**From:** [David M Zabell](#)  
**To:** [Emily Dickson](#)  
**Subject:** City of Sydney response to SSD 7484 Mod 4 - Sandstone Precinct - Changes to the Lands Building - R/2014/39/M  
**Date:** Wednesday, 7 August 2019 1:03:44 PM  
**Attachments:** [image005.png](#)

Thank you for inviting the City to comment on the proposed modification. City staff raise no objections subject to the following comments and recommendations being adopted:

Courtyard Paving

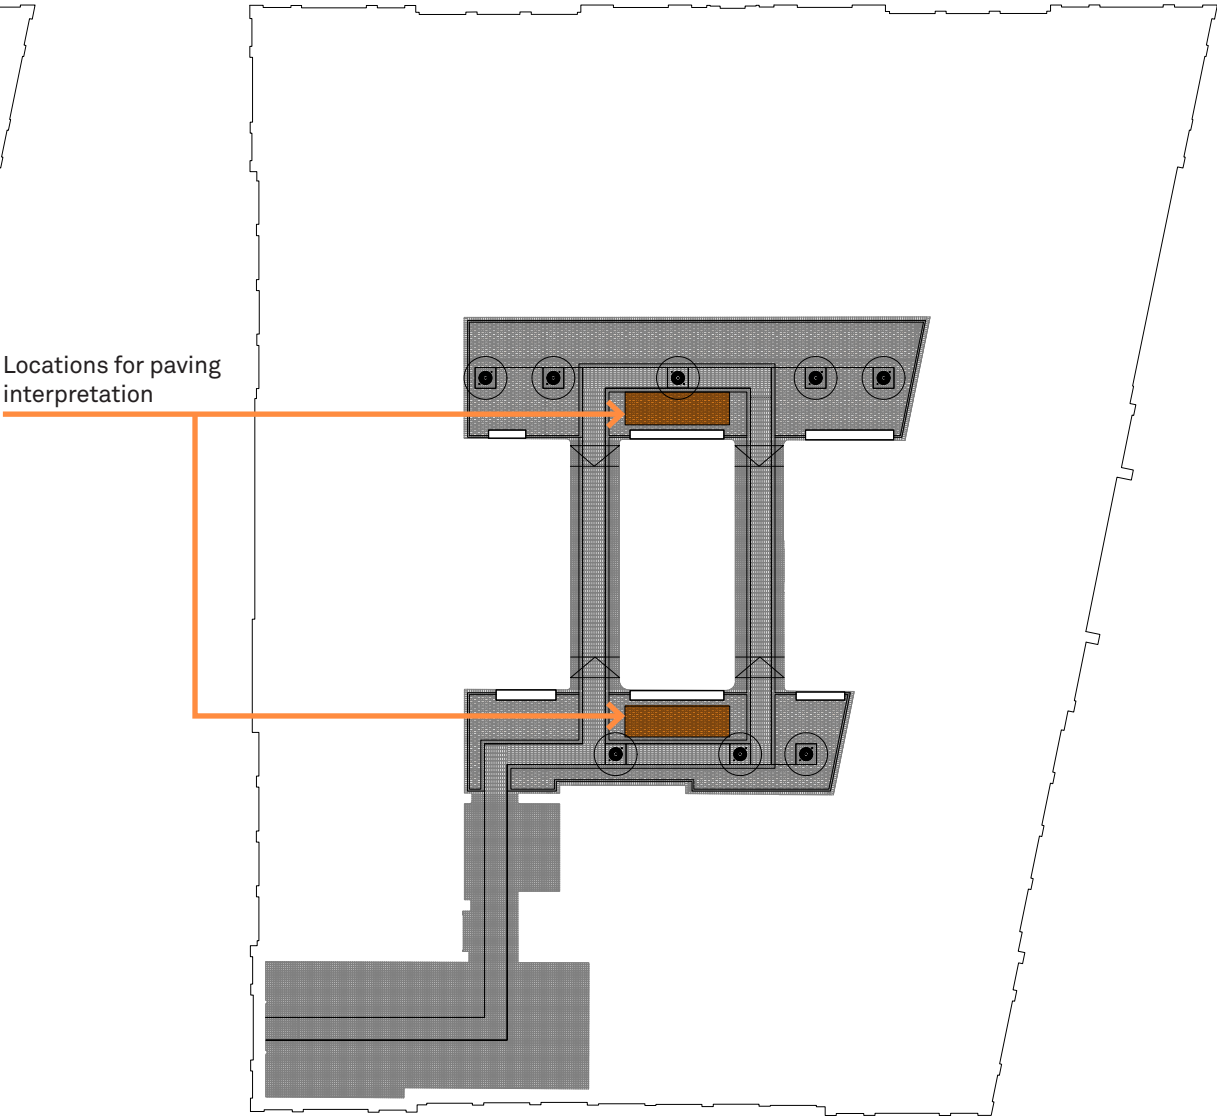
- The courtyard toilet structures and related iron gangways are early fabric and are not without significance. While 'cleaning up' the internal facades acknowledges their proposed public presentation to the courtyard circulation network, it should not remove all evidence of historic use. Retention of some ironwork in situ should be considered for interpretation. Substantial elements of the iron gangways, including the brackets should be salvaged for interpretation on site and the toilets should be covered in the revised interpretation plan.
